**Enguang Lee - Online Submission from Michael Roberts (object)**

Submission for Job: #1096 Residential, Commercial and Tourist Development (Concept Plan)

Site: #695 07\_0010 Ocean Drive, Lake Cathie

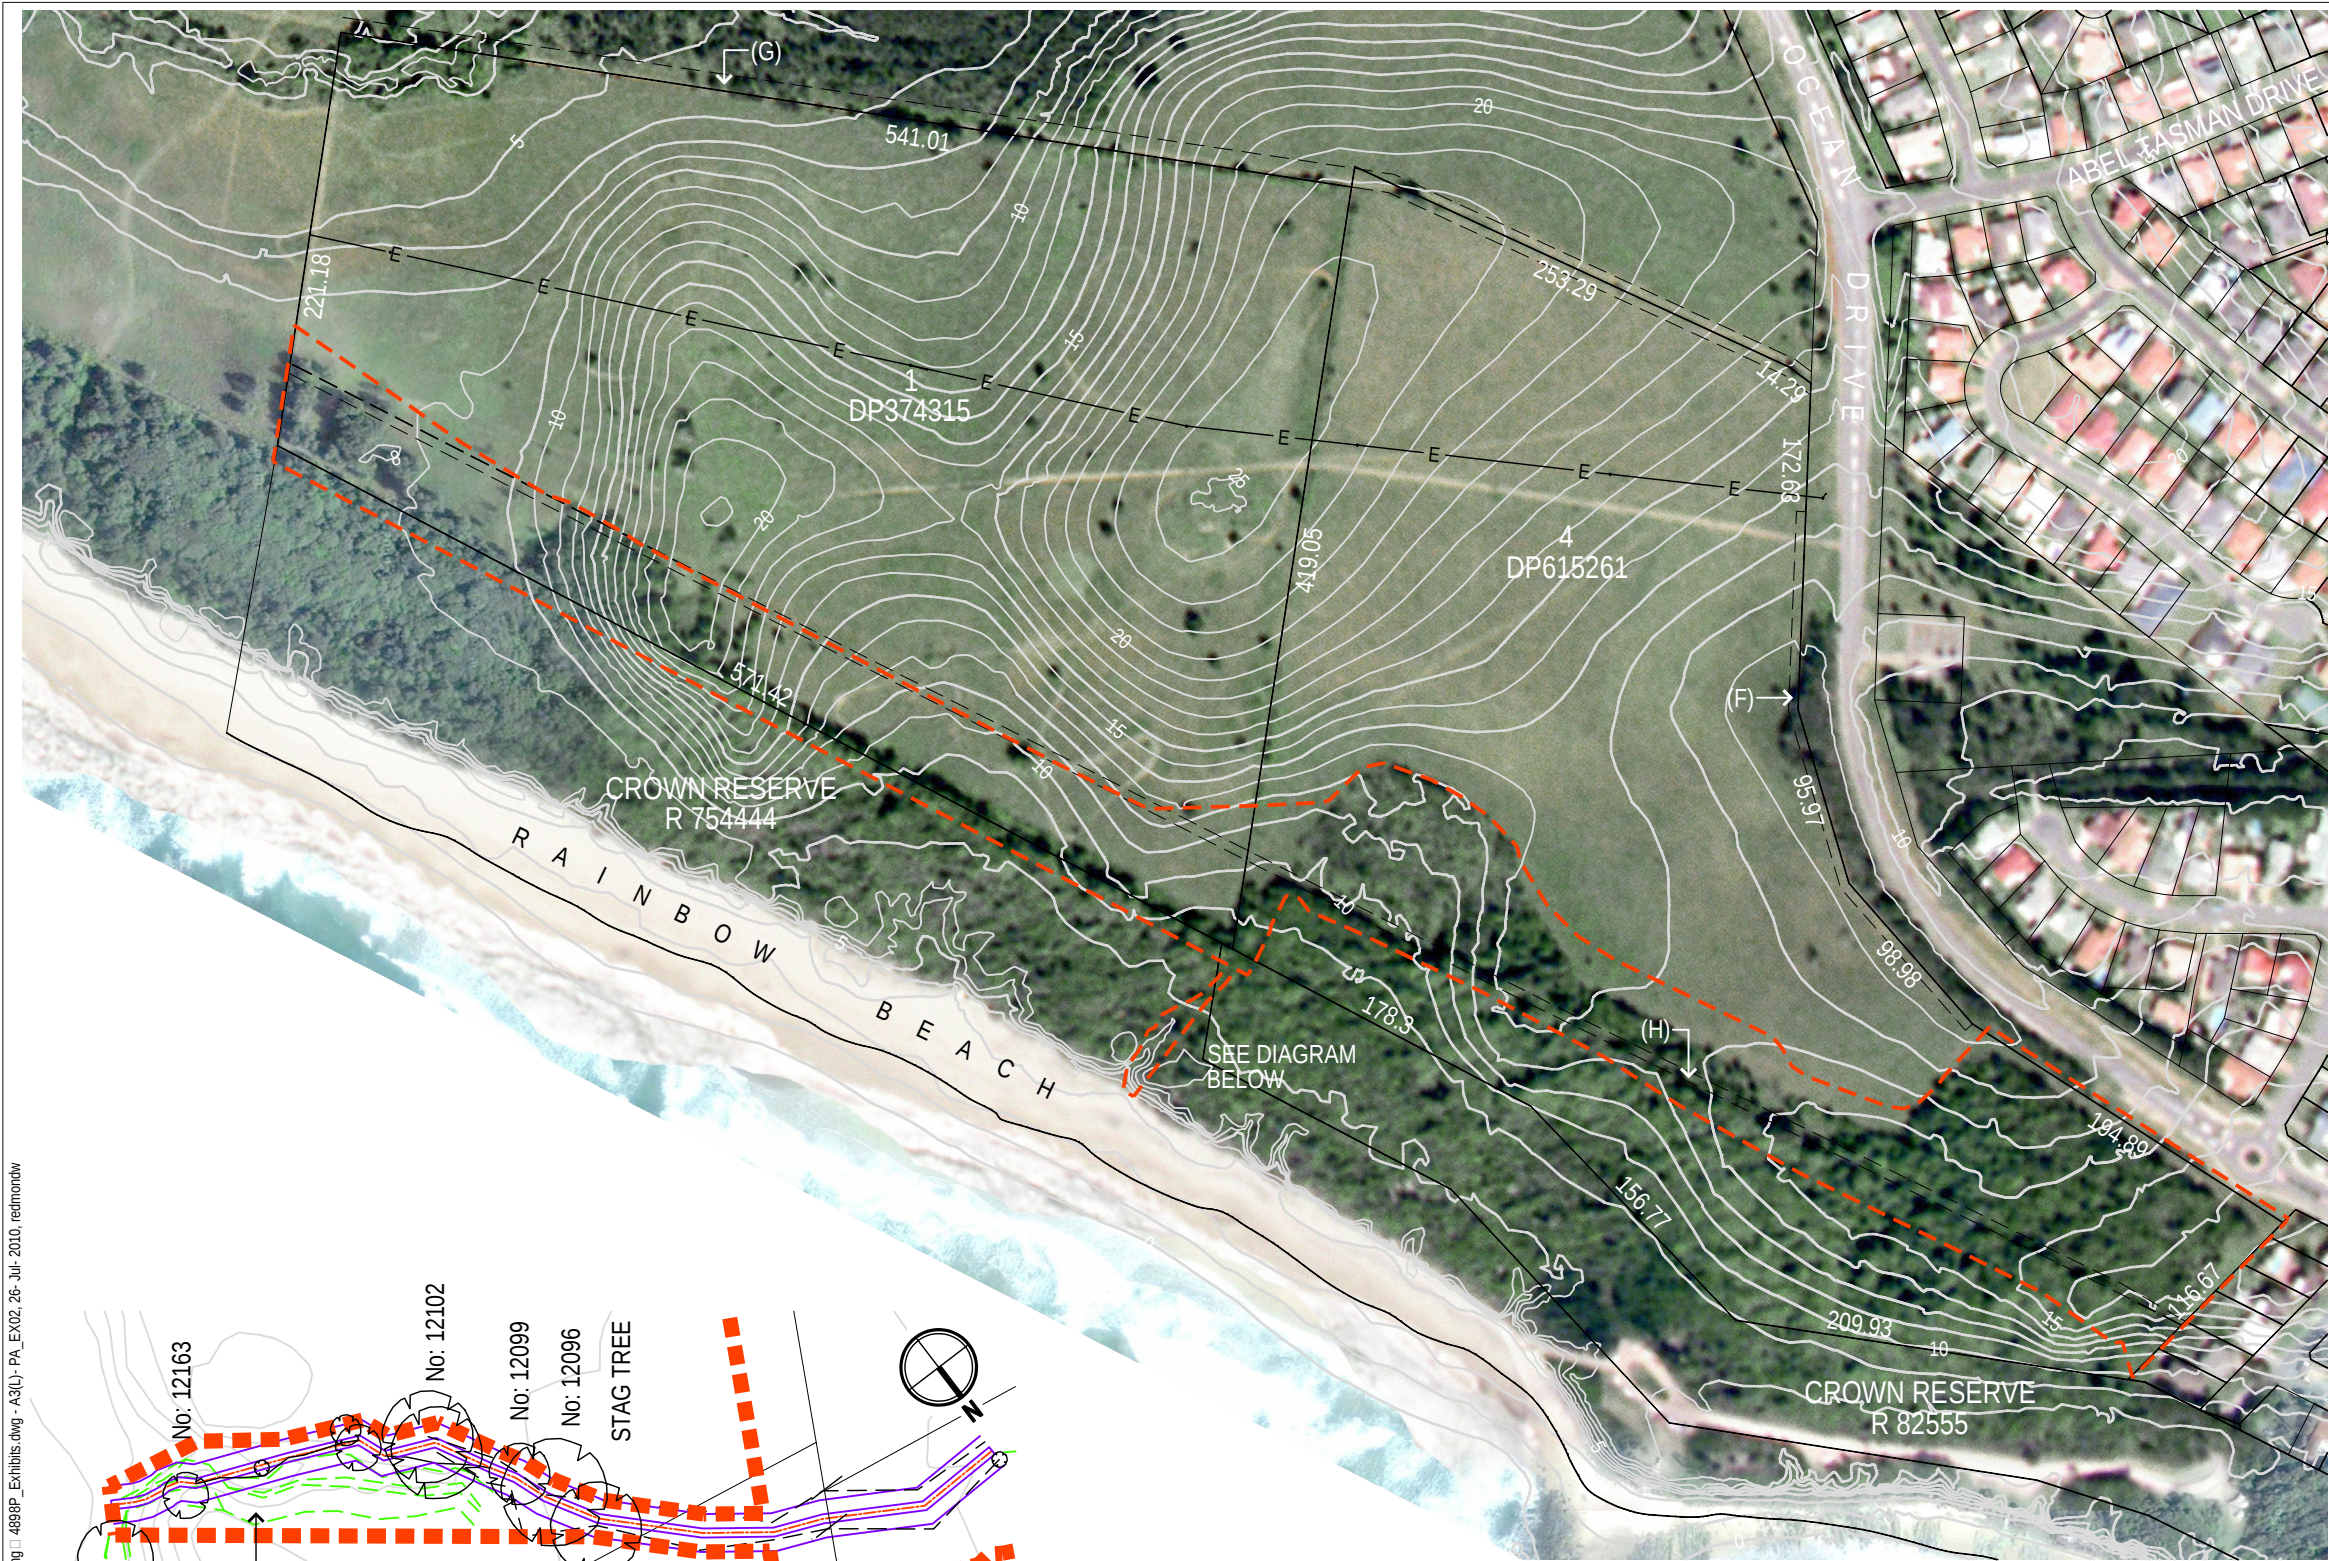
2. SEPP 26 Littoral Rainforest & SEPP 71 Coastal Protection - The existing Littoral Rainforest located to the east of the site is of great value to the local community and aboriginal heritage. Specific protection measures need to be adopted to preserve this unique stretch of environment. The environmental assessment outlines revegetation works and the establishment of buffers between the development and the rainforest. In order to further minimise disturbance, the buffer distance between the existing rainforest fringe and any proposed development (including roads & cycleway) should be a minimum of 100m.

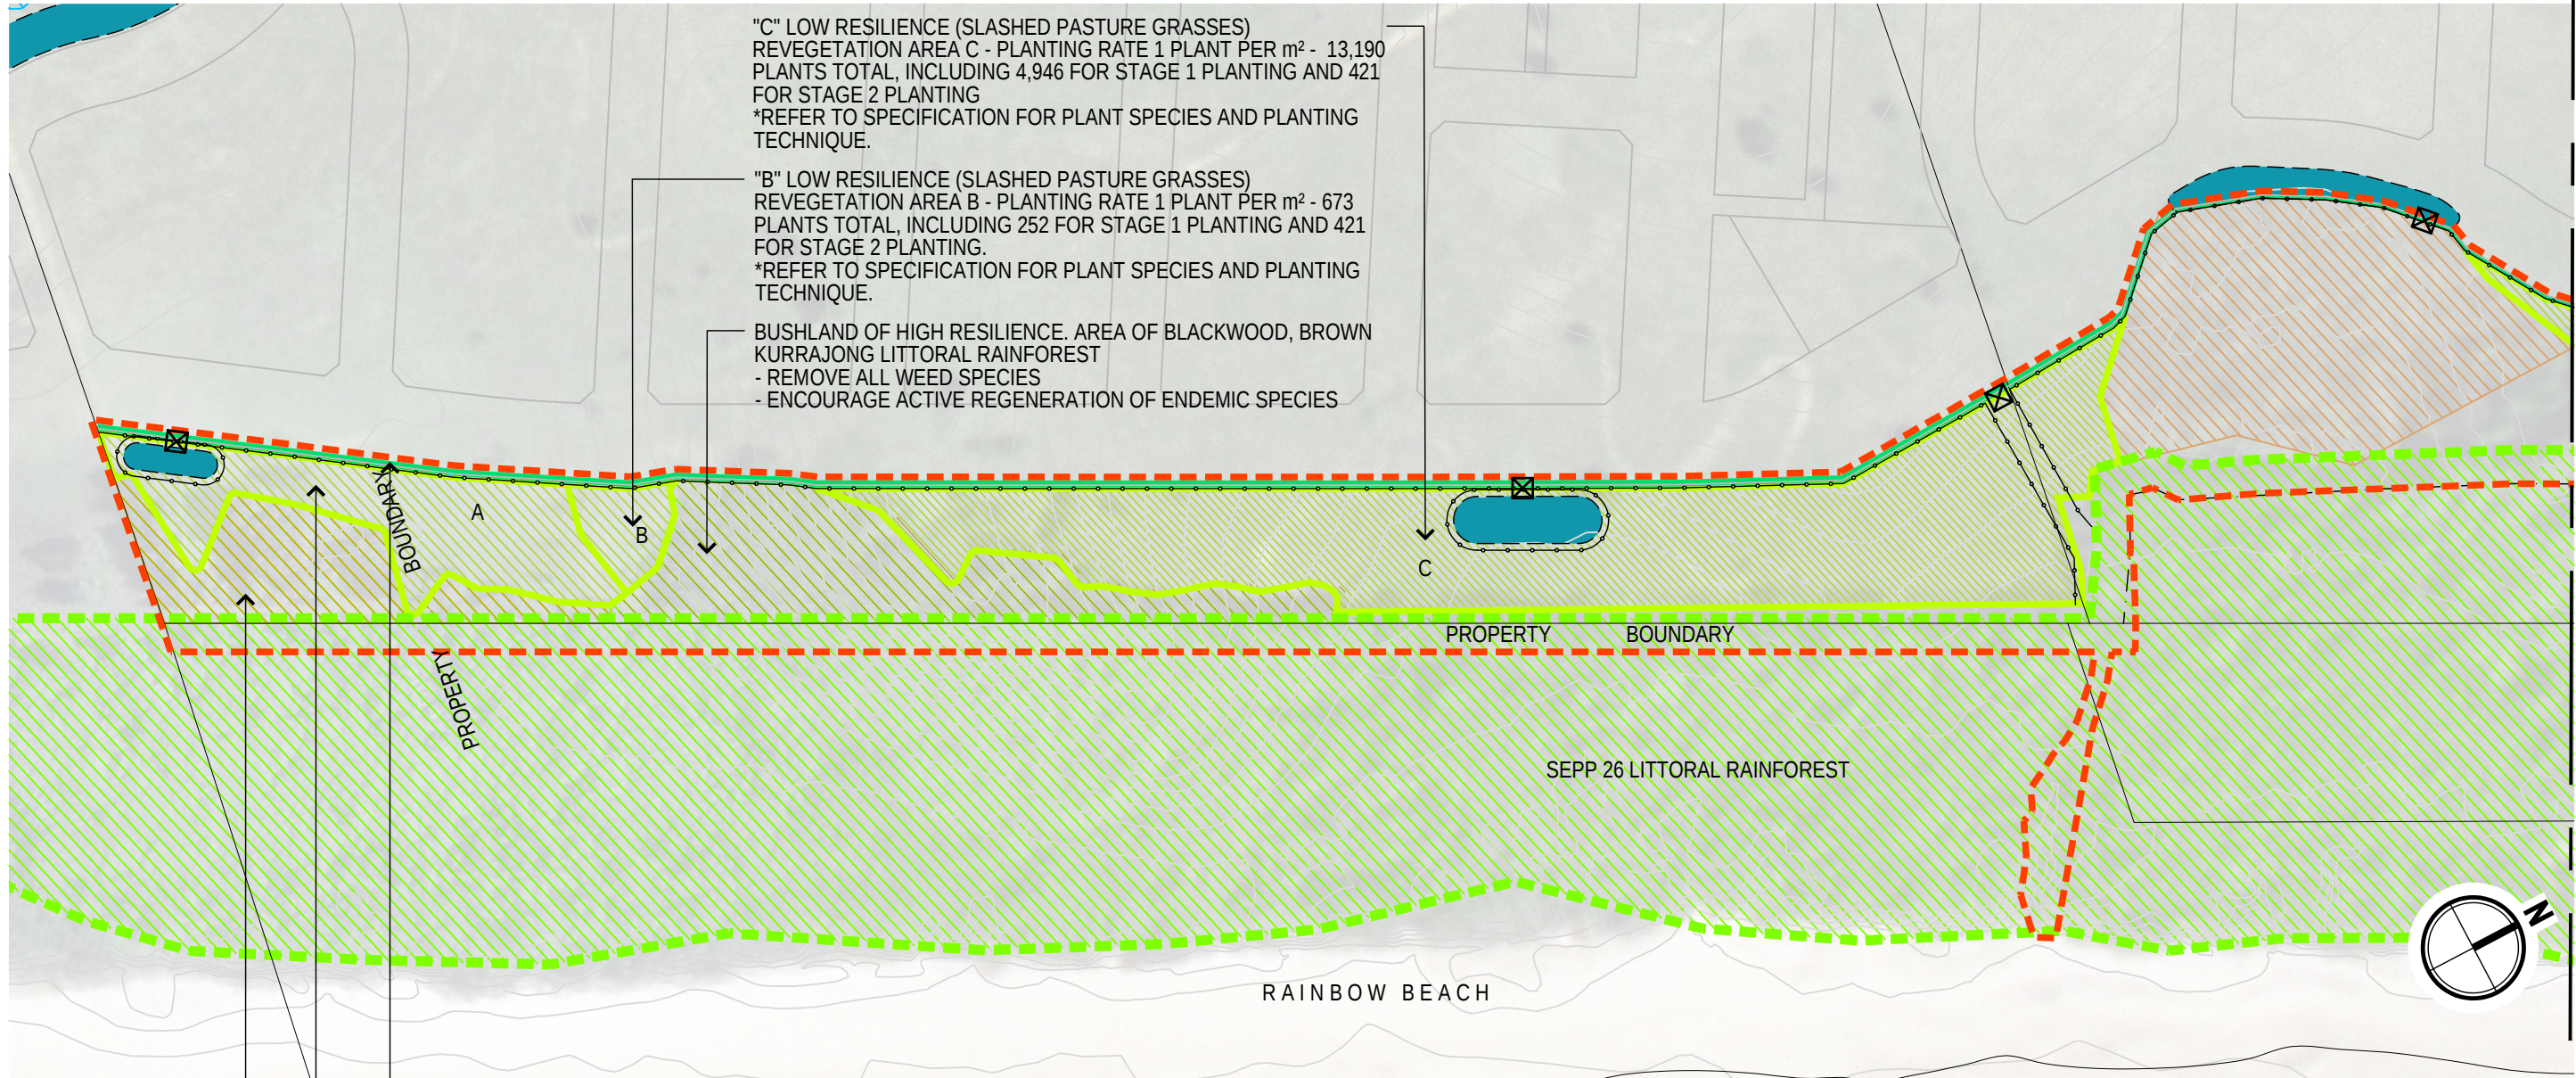
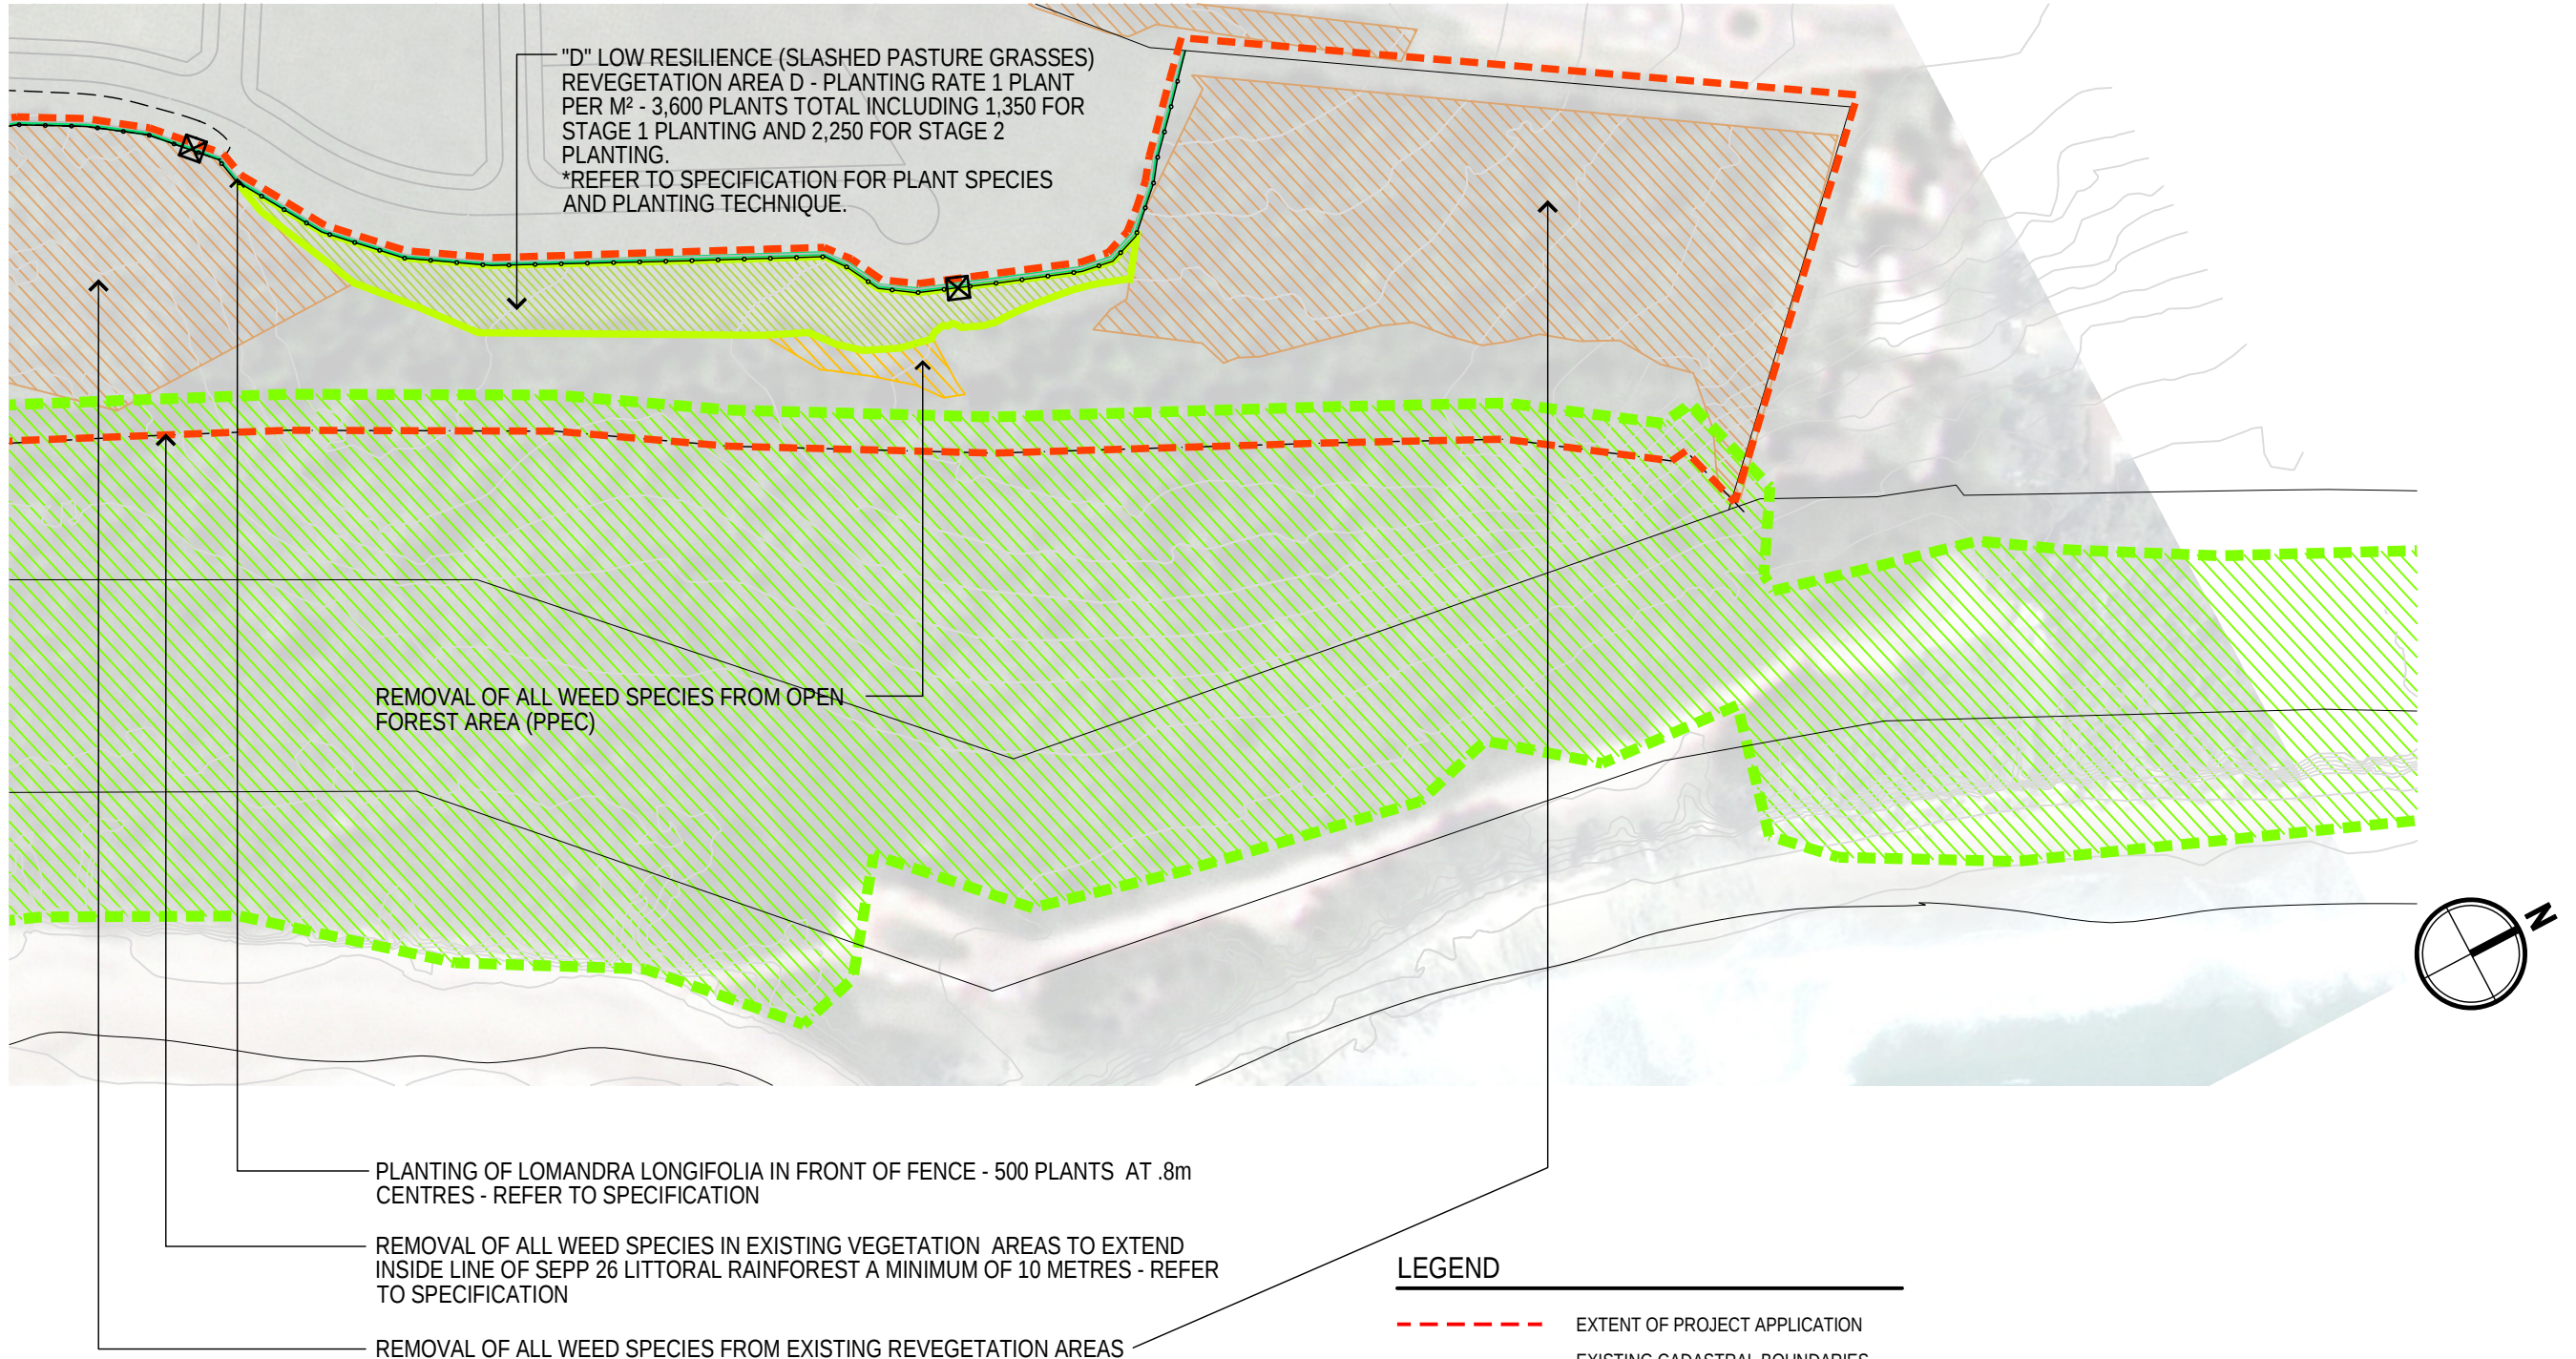
1. Visual amenity - In my opinion more should be done to ease the visual impacts of the proposal in this locality. Further provision for open space & landscaping along the northern hillside of the site. Possibly a vegetation screen along the proposed noise wall and detention basin adjacent to Ocean Drive. This will ease the visual impact of the development when travelling along Ocean Drive southbound. Being a resident that lives in Abel Tasman Estate (Bligh Place), it is aesthetically pleasing to have views of the ocean, rainforest & grasslands associated with this site.
